**Written Representation
for the
Royal Society for the Protection of Birds**

27 January 2026

**Application by Uniper UK Limited for an Order
Granting Development Consent for the Connah's Quay Low Carbon Power
Project**

Planning Inspectorate Ref: EN010166

Plate 1: Main Development Area

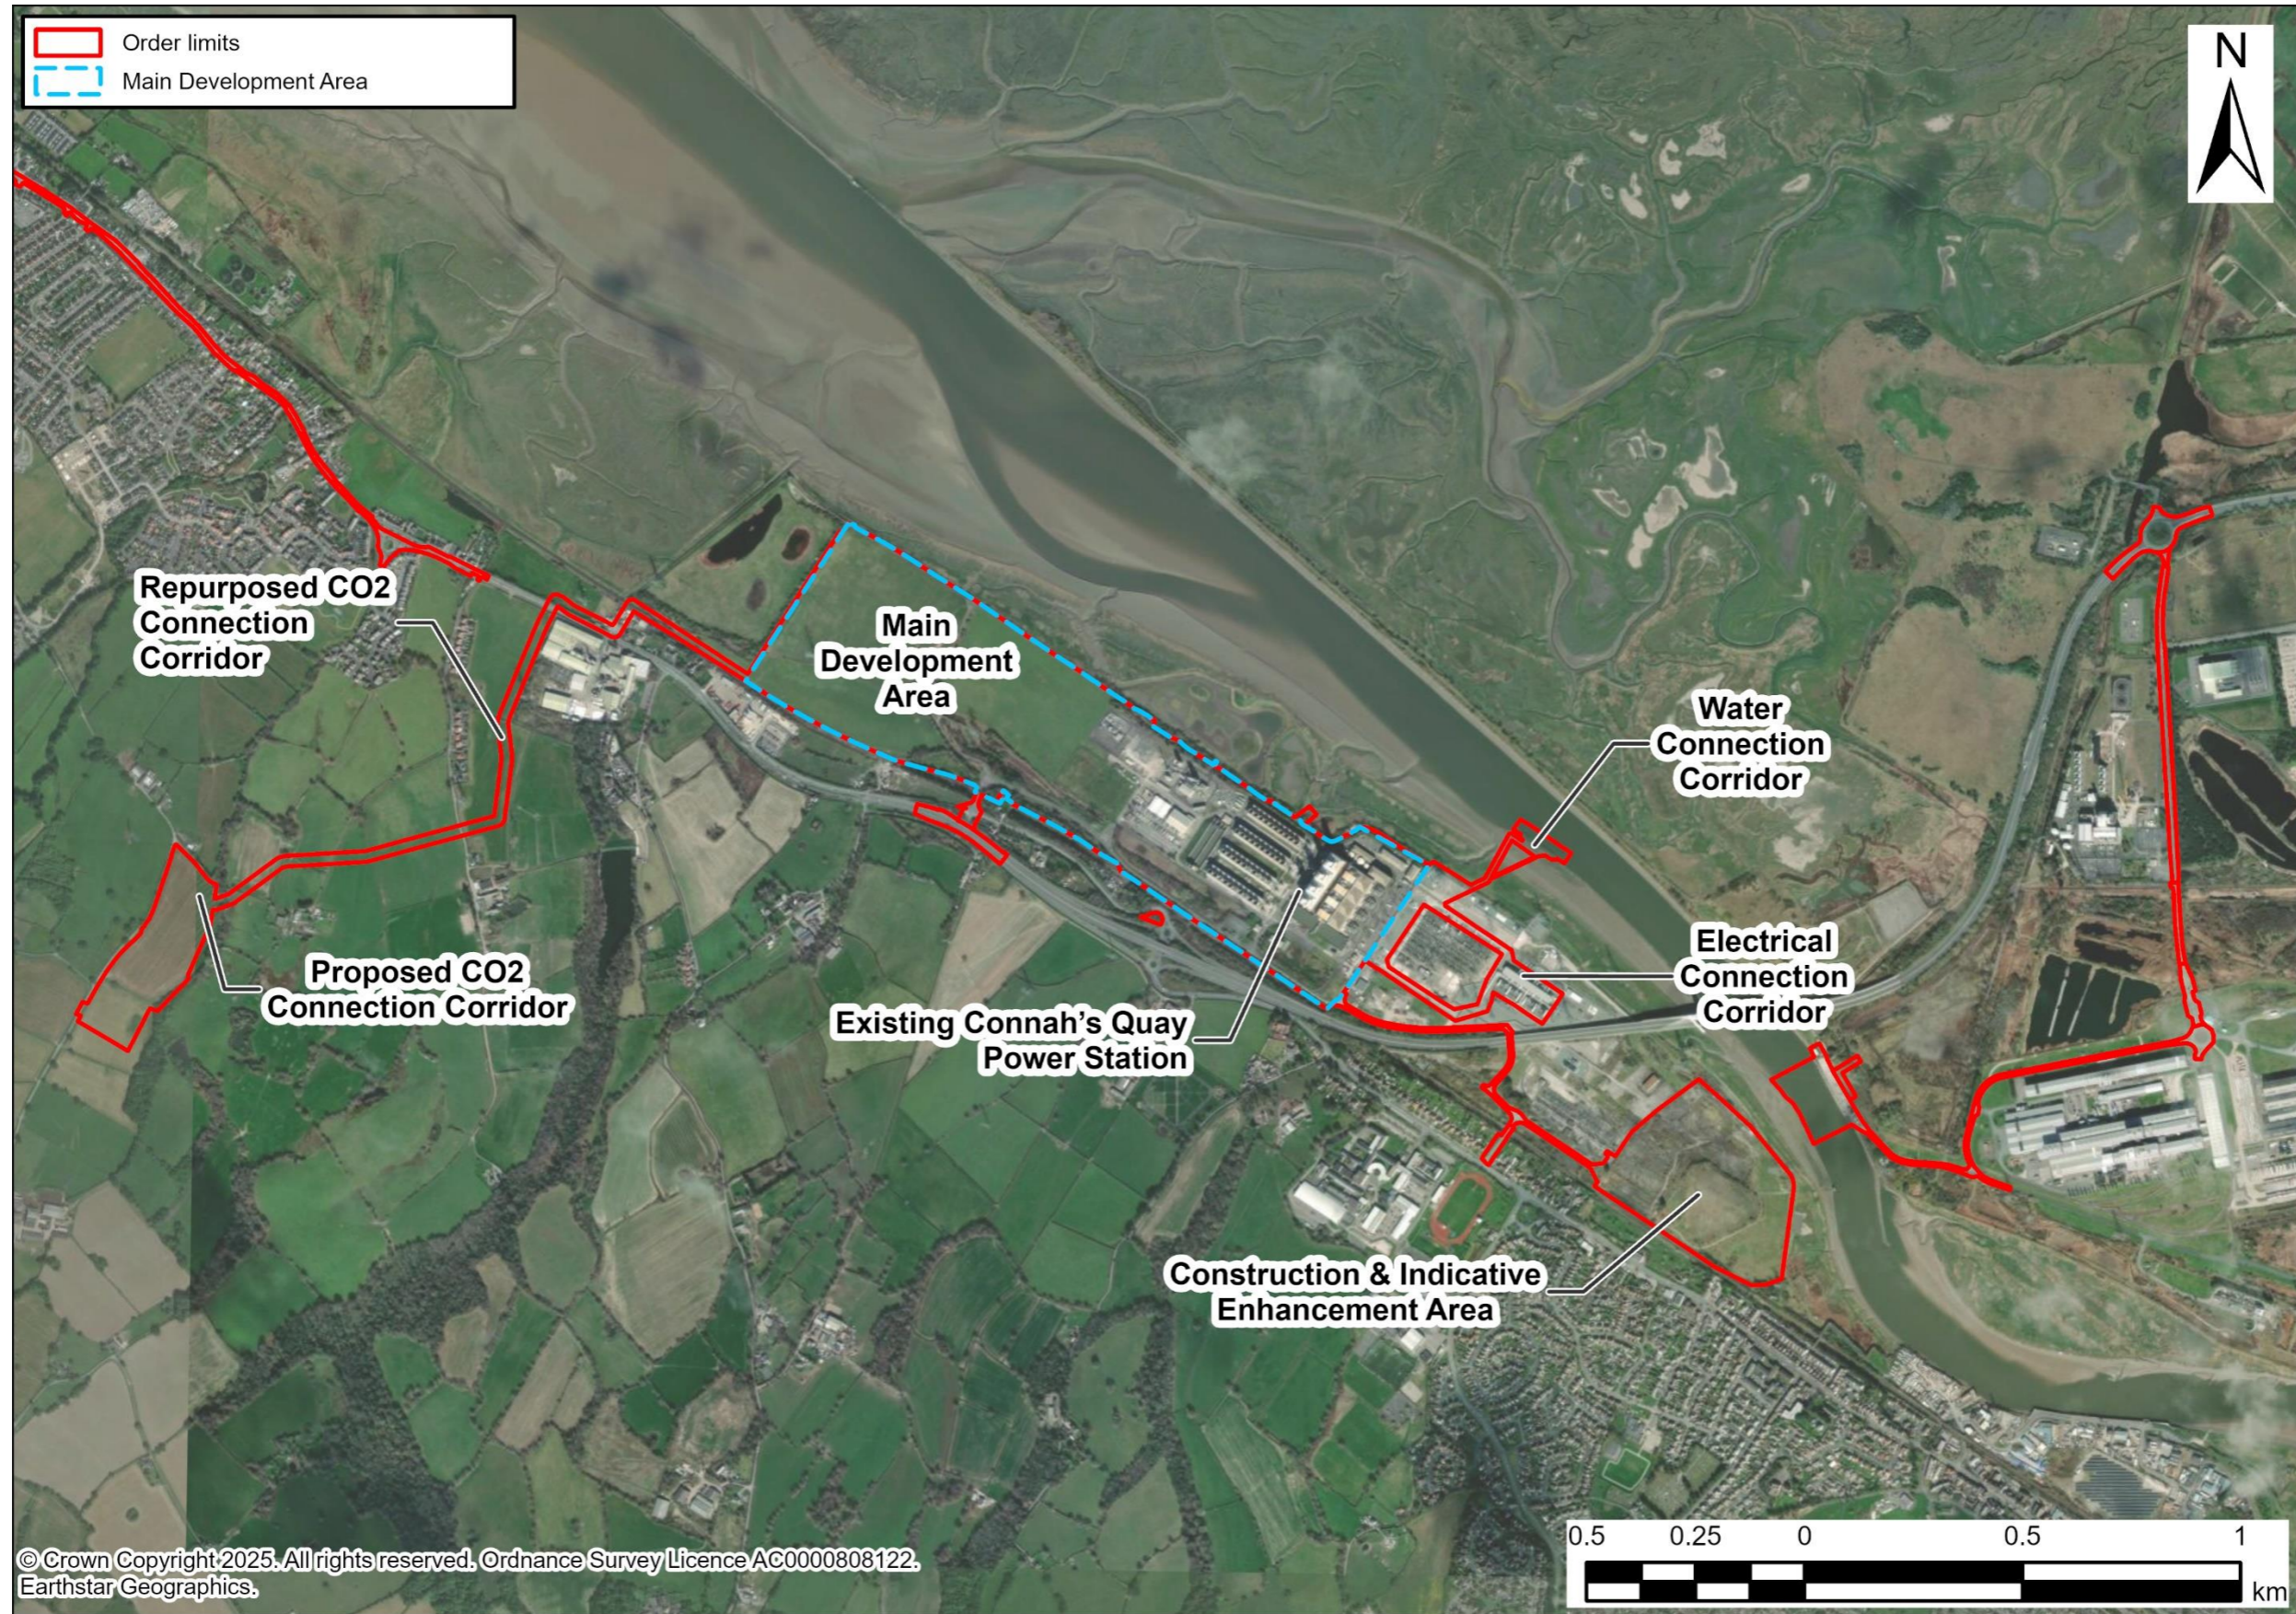
- 4.7. Chapter 11 of the Environmental Statement (ES) (APP-049) identifies that habitat loss will occur within the Main Development Area. The western part of the fields at the Main Development Area will be used as a 'laydown area' during construction and will be reinstated into pasture on completion of works. The remainder of the fields will form part the new power station footprint, resulting in permanent habitat loss. This will have a direct impact on birds during and after construction. In total the ES identifies some 11 ha is likely to be temporarily lost and 15 ha permanently lost.
